# Rezoning Transportation Analysis

Petition Number: 2024-003

## Revision Log:

Date	Description
2-21-24	First Review (IW)
3-20-24	Second Review (IW)

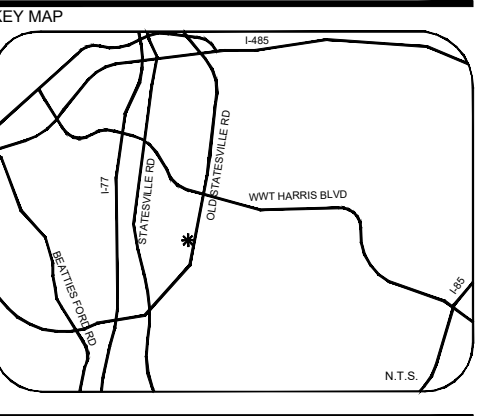
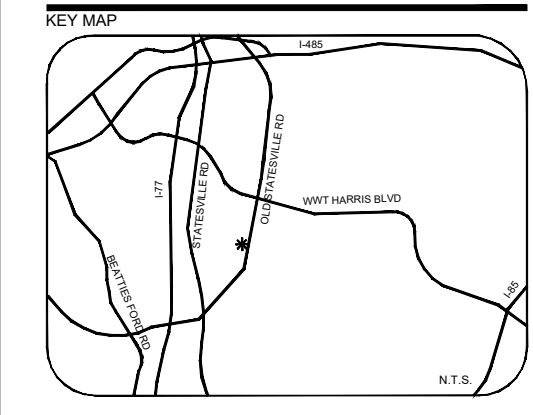
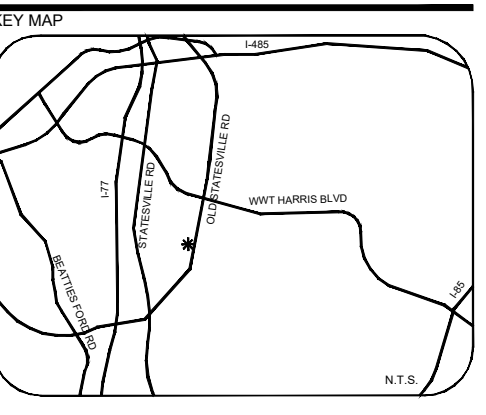
- b. **Ratcliff Lane:** Location of future back of curb and gutter needs to be moved to 17.5 feet from the road centerline per Article 33 in the UDO.

CLDSM standard U-03A2 Local Residential Wide Street

Label and dimension the curb and gutter from the centerline for each road on the site plan.

**Clarifying Comment 03-20-24:** The site plan calls out curb line to match existing but does not state what that existing dimension is. Conditional note 3.g. states that future boc is 17.5'. Add additional information to call out on site plan to show that both of these items are stating 17.5' from centerline.
